KITITAS COUNTY

DEPARTMENT OF PUBLIC WORKS

MEMORANDUM

TO: Jeff Watson
FROM: Christina Wollman, Planner II *CW*
DATE: September 27, 2011
SUBJECT: Mystic Land SG-11-00005

RECORD OF SURVEY		
PREPARED FOR BILL HINKLE		
THE NW 1/4 OF THE SW 1/4 AND THE SOUTH 1/2 OF THE SW 1/4, OF SEC. 10, TOWNSHIP 19 NORTH, RANGE 16 EAST, W.M.		
KITITAS COUNTY	WASHINGTON	
DWN BY D. PIERCE	DATE 06/2011	JOB NO. 09131
CHKD BY D. NELSON	SCALE 1"=200'	SHEET 1 OF 1

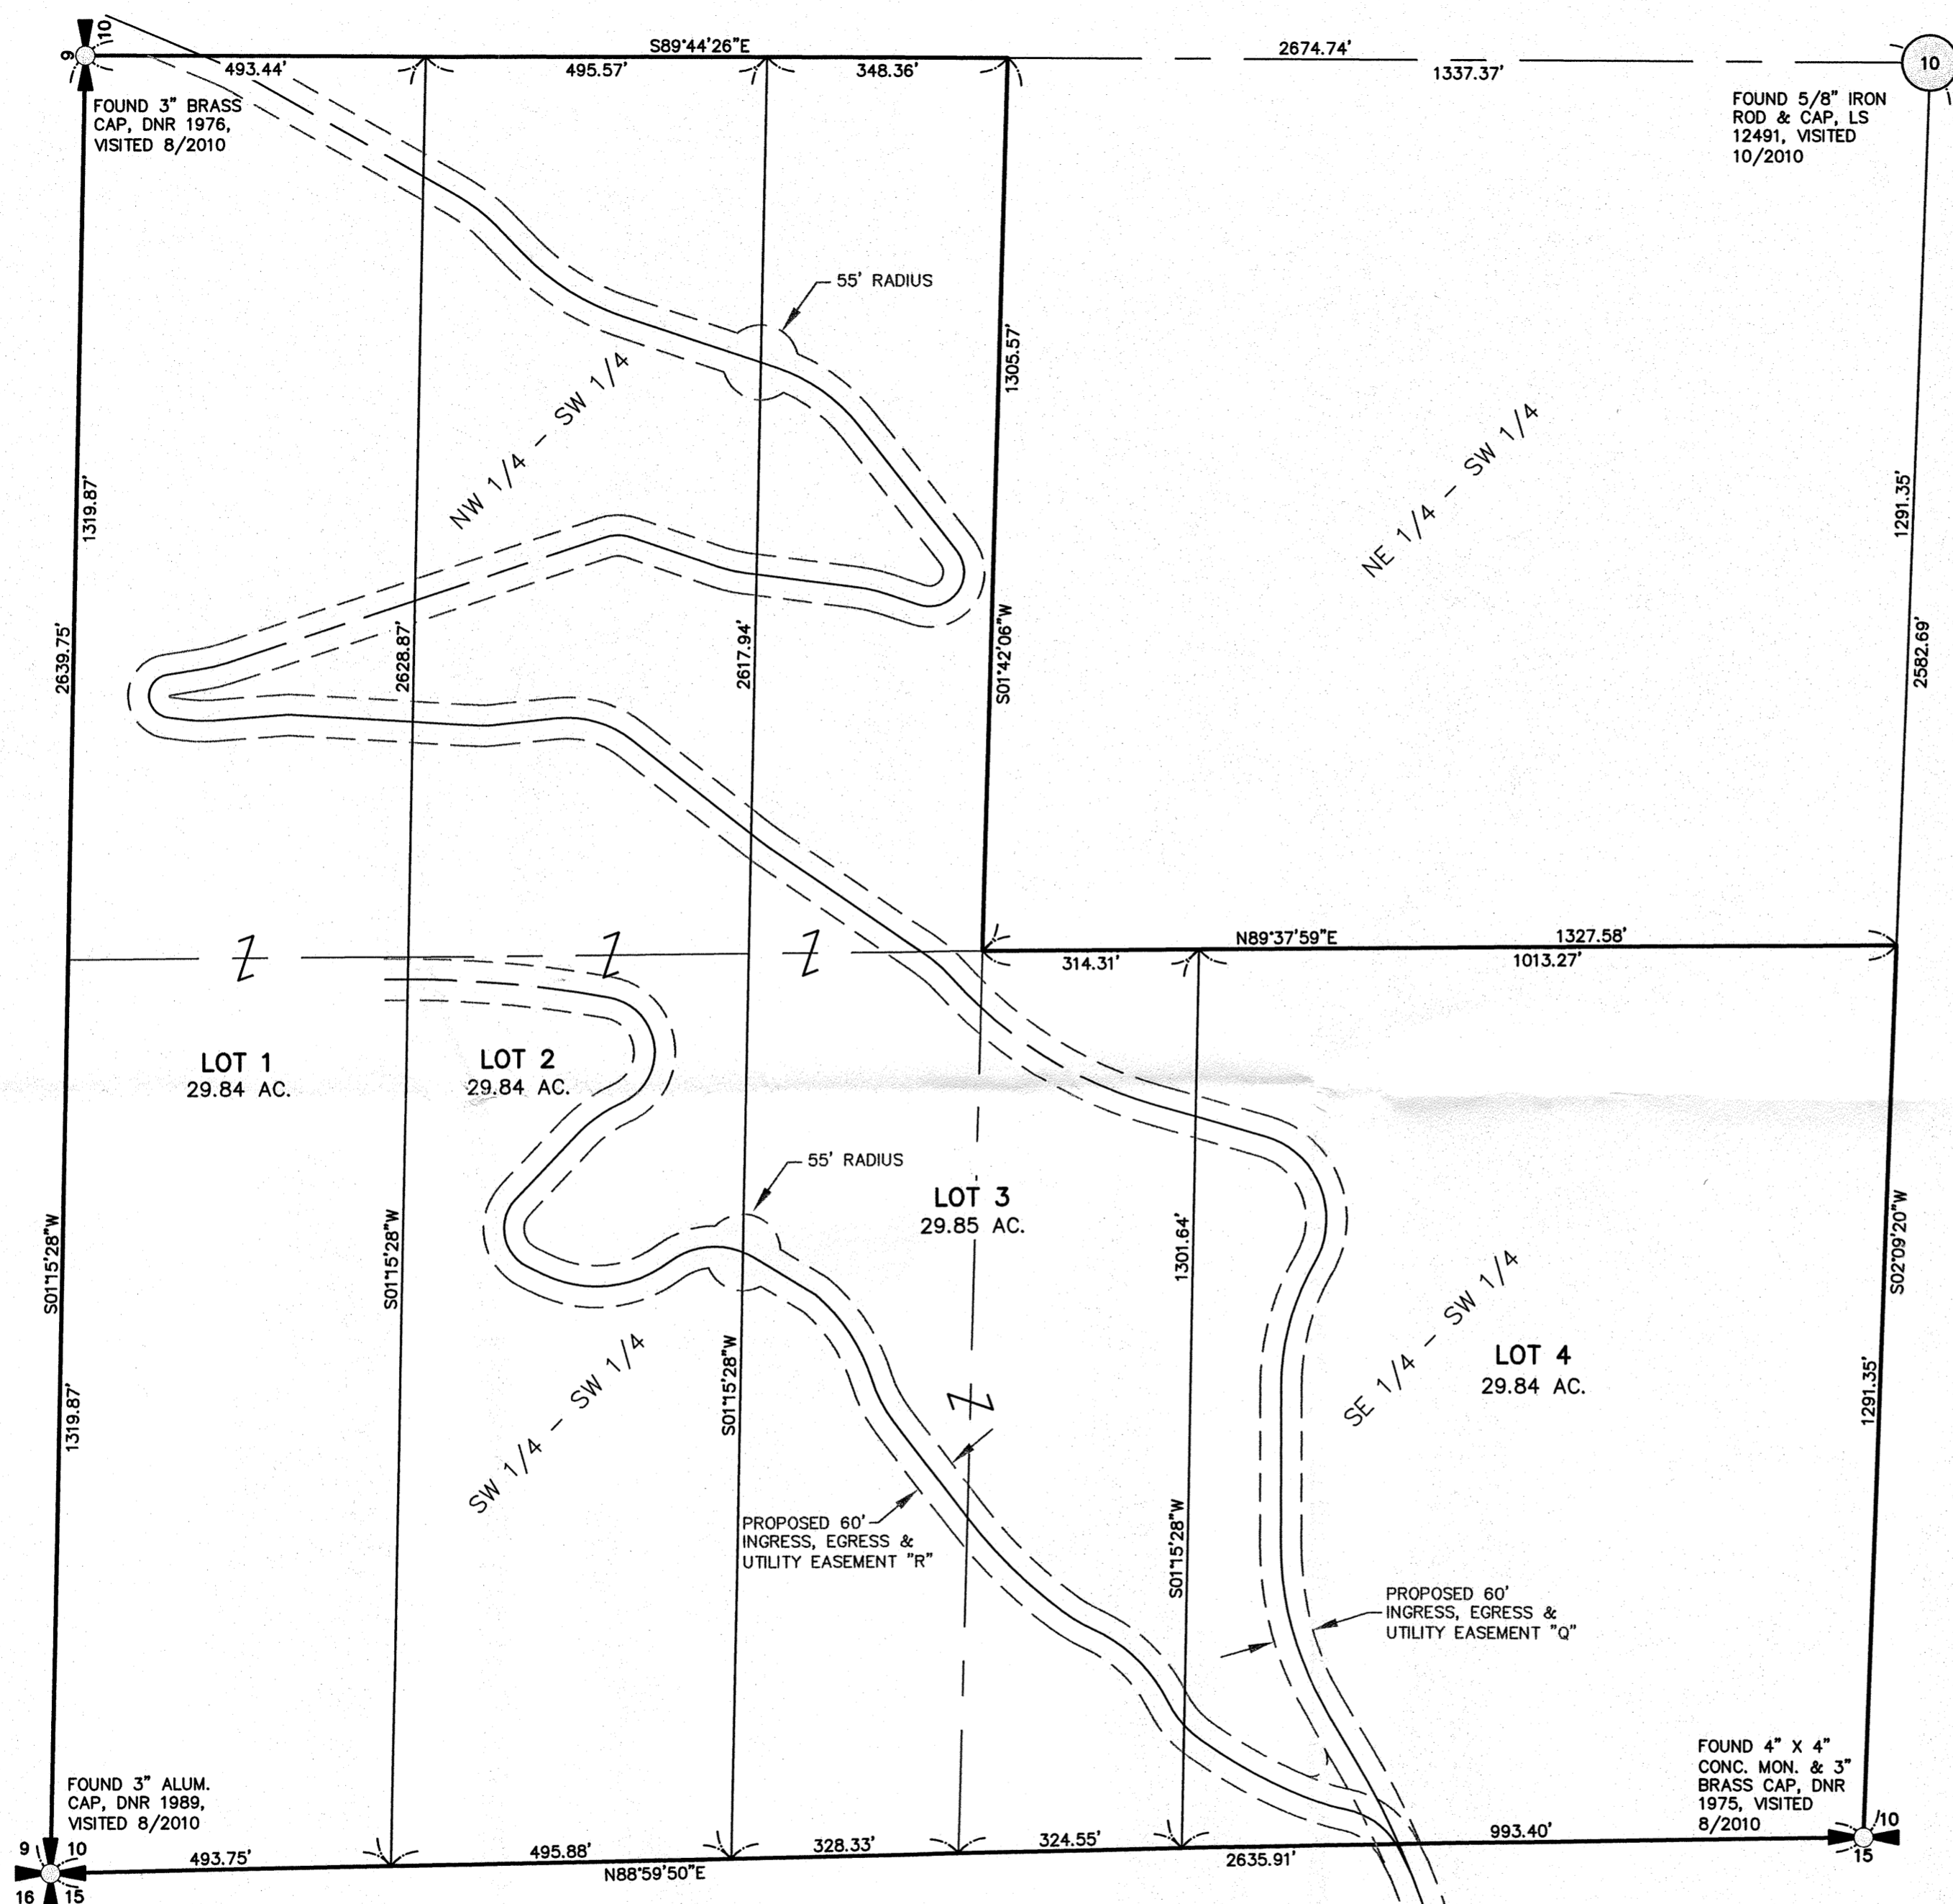
1. Information on the proposed access with recorded easement(s) shall be provided.
